Arun District Council
Arun Civic Centre
Maltravers Road
Littlehampton
West Sussex BN17 5LF
Planning & Building Control General Enquiries
Tel: (01903) 737756 Fax: (01903) 730442
Dx: 57406 Littlehampton
Minicom: 01903 732765
e-mail: planning@arun.gov.uk
website: www.arun.gov.uk/planning

Application No: BE/79/20/RES
Site Address: The Cottage Shripney Road Bognor Regis PO22 9PA
Description of works: Approval of reserved matters following BE/63/17/OUT & variation of condition BE/131/18/PL for replacement dwelling at the southern end of site (Phase 1) to reposition driveway & car port (resubmission following BE/58/19/RES).

Thank you for your internet representation made on 3rd September 2020 which has been recorded as no objection with the comments as follows:

Site Plan -
Proposed

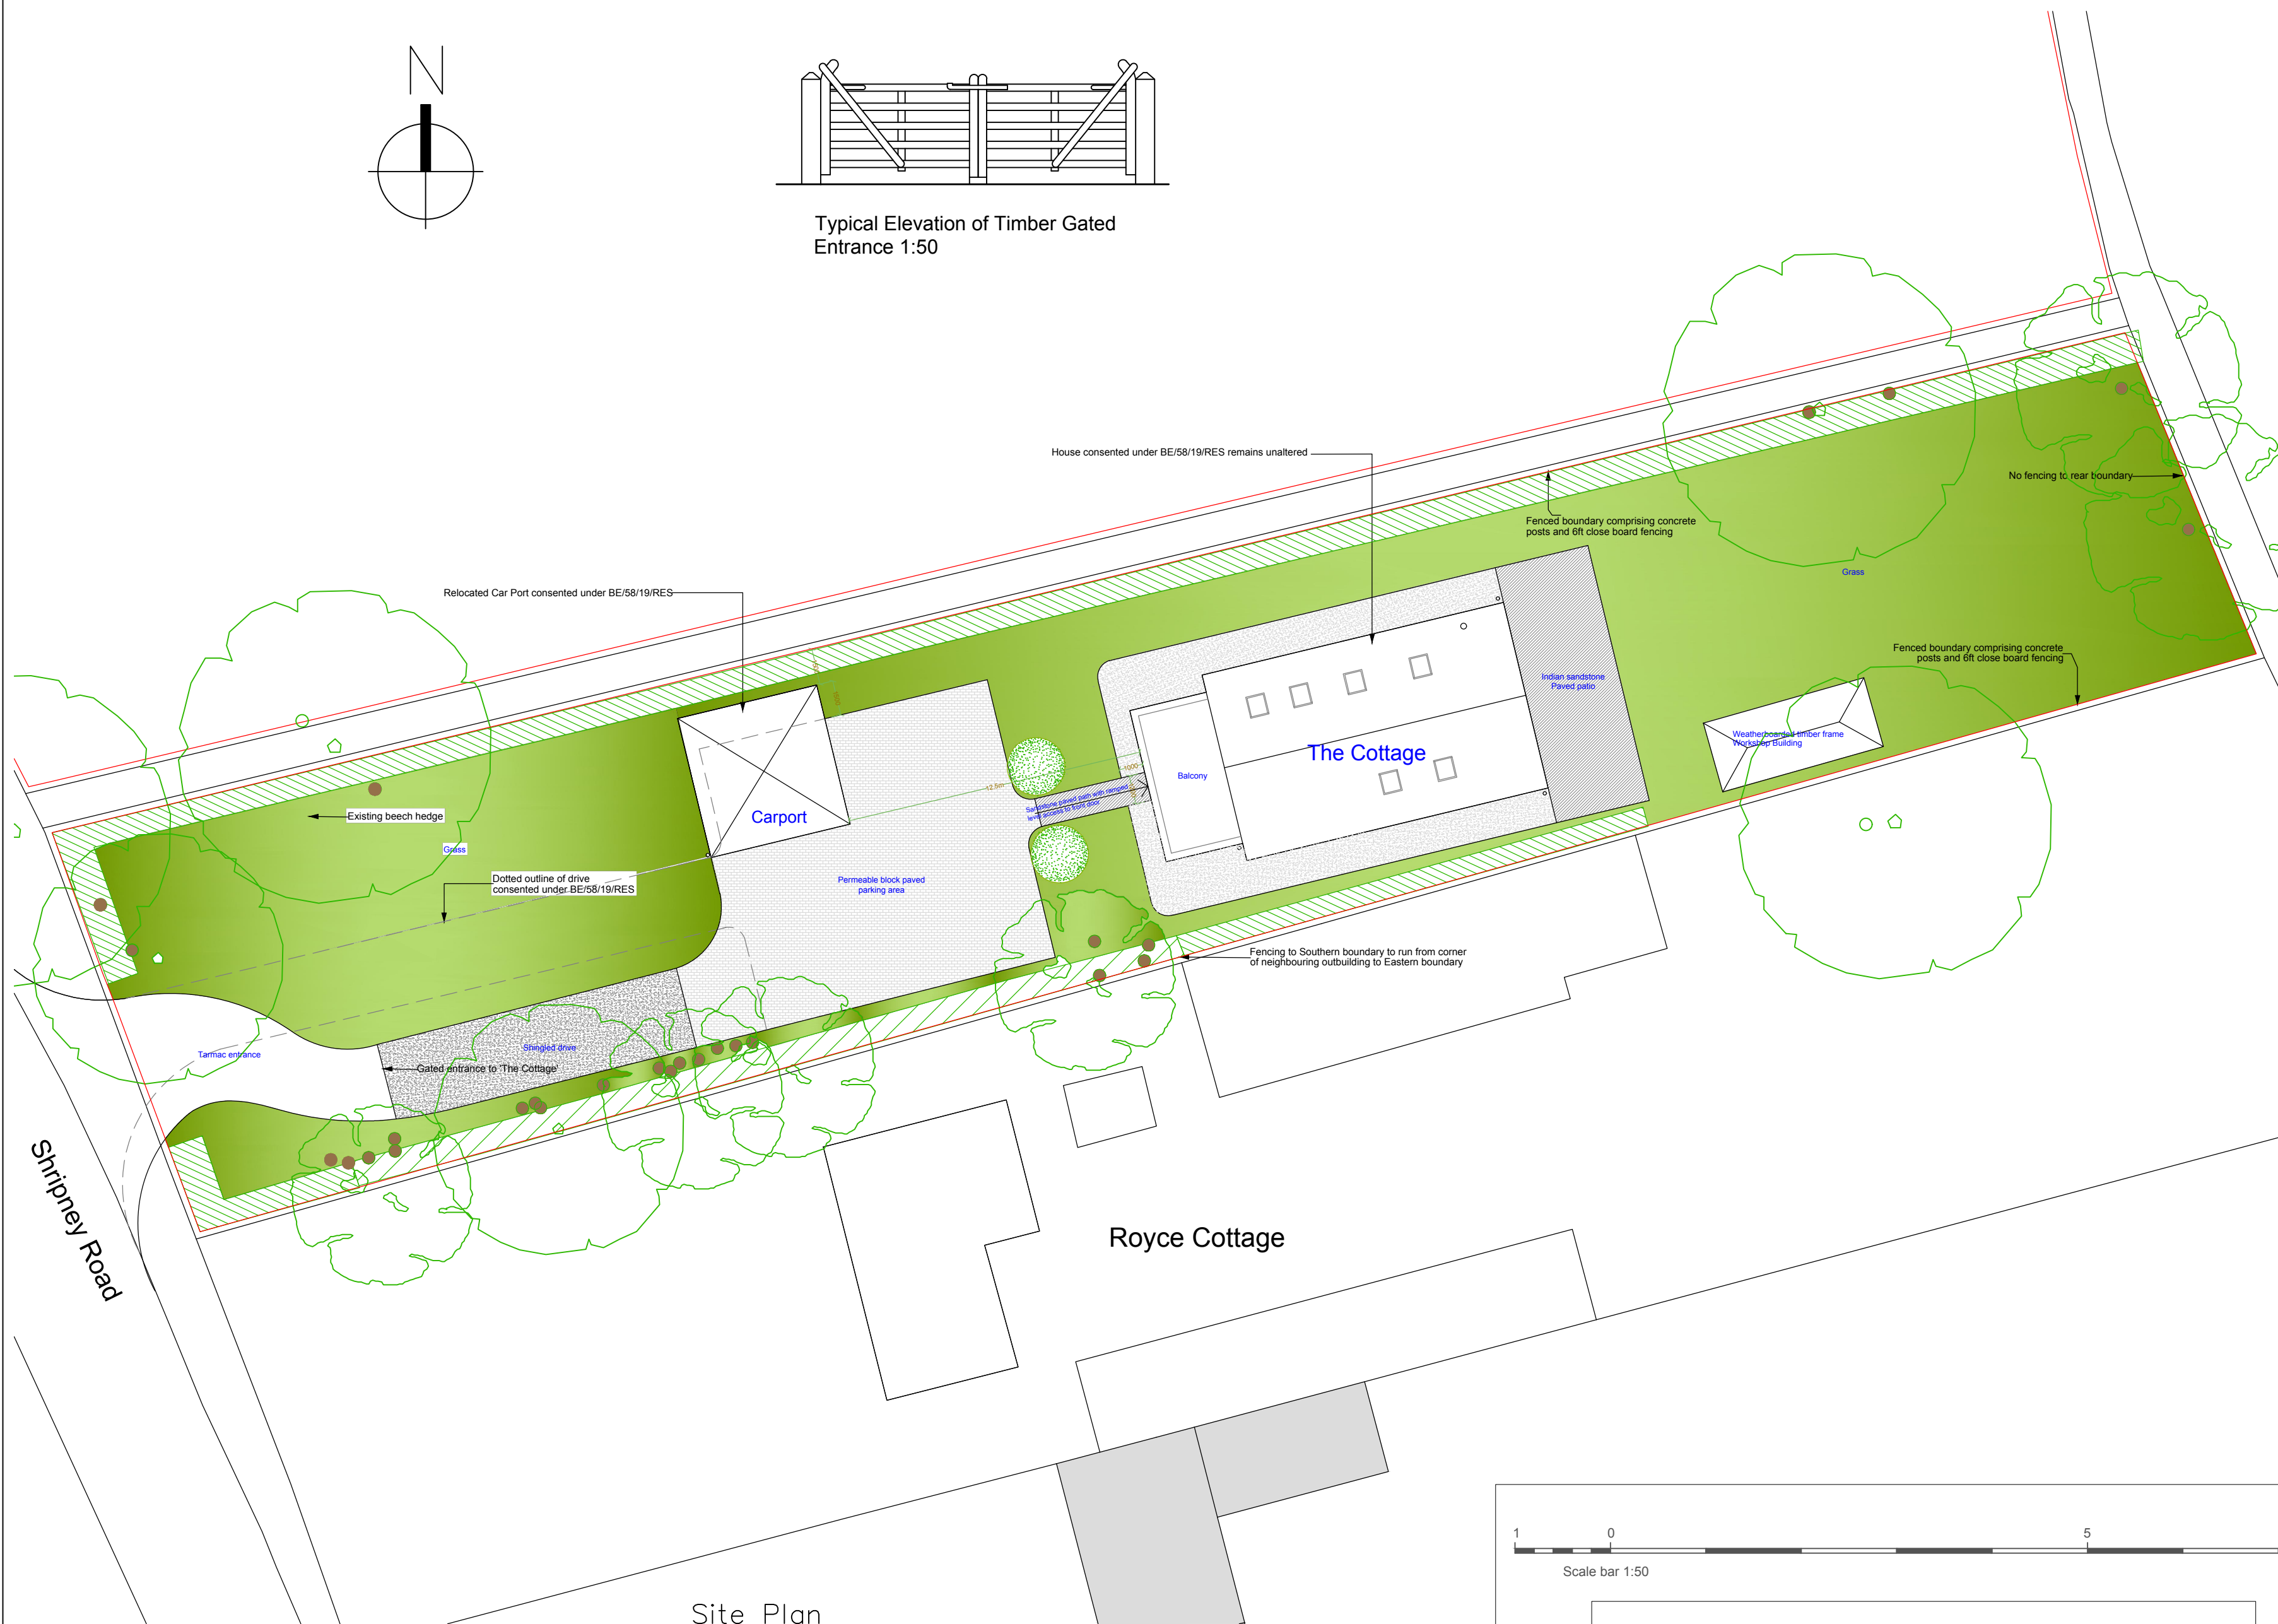
No objection but comment that the gate to the driveway should be set far enough back for vehicles to access without protruding onto the A29.
